Comments as to Planning Applications 2021/1089 & 2021/1090 (AKA MU1 Development), 30/10/2021.

Drawing: Boundary Sections

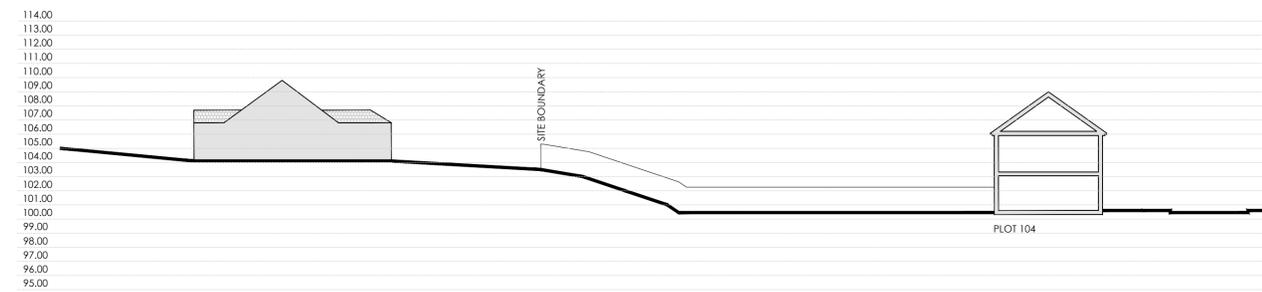
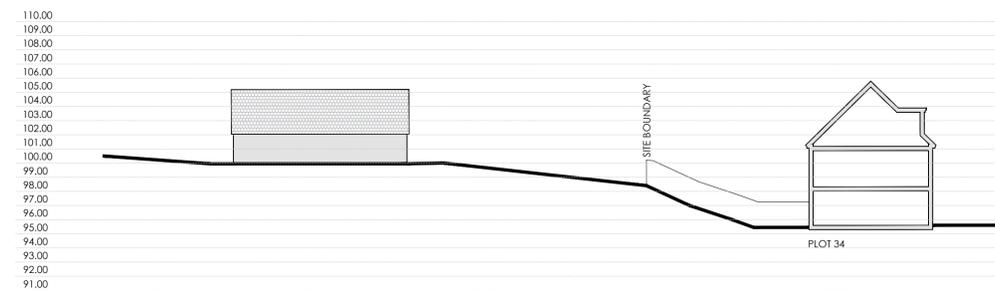
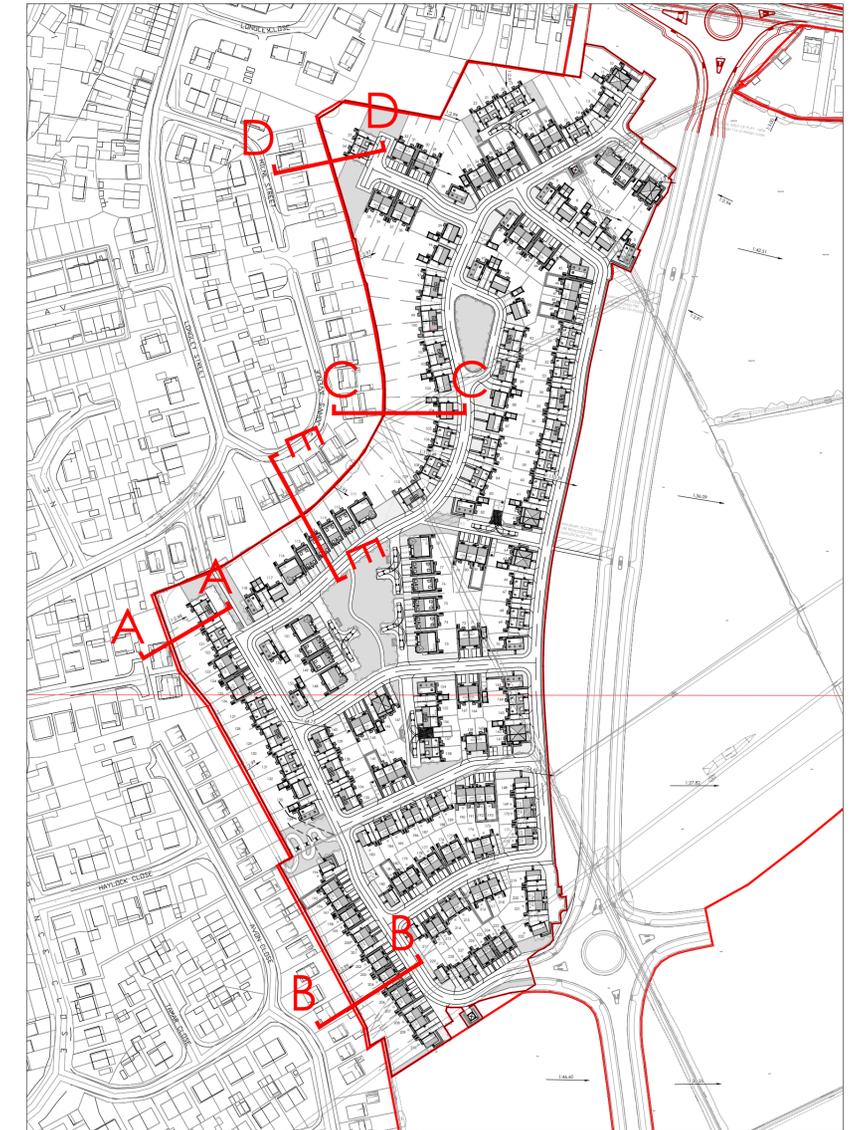
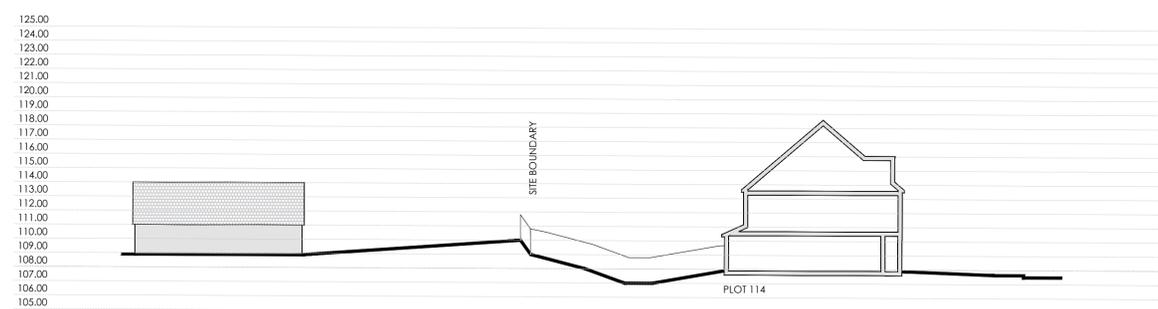
Furthermore, one major issue is that Bob Murray has factually misled me, Barnsley council, and the residents of Barnsley. Bob categorically stated to me, in a meeting with Cllr Fielding and Cllr Wright, that the earlier plans of three-story houses backing onto current residential bungalows was a mistake and would be removed before plans were submitted.

In the plans put into submission, there are three-story houses backing onto the properties of current residents that live in bungalows. For examples of such houses, visible on the submitted Phase 1 Residential Development Plan, you can look at Plot 101 (a three-story house, code MY P-412, also known as "opporto"). Further "opporto" houses include plots 97, 98, 102, 119 and 120. In addition, further three-story houses such as plots 112-115 ("Naples" house); 121, 122, 127, 128, 131 & 132 ("Rosas" house) back onto current residential bungalows, acting as an imposition and privacy concern to current residents.

The sad reality is that due to a complete lack of buffer zones between MU1 and current areas, there is a large impact on current residents. I have already made it clear in the past that three-story properties do not belong in a position where they back up to current bungalows, but a readjustment of these plans, creating buffer zones with trees, can mitigate issues that would occur even with a two-story property. Removing 5 metres from each side of the link road and creating a buffer zone would be more than sufficient and create a green corridor, where trees and grow and wildlife would not risk harm, as well as act as a visual barrier between residents and the new build.
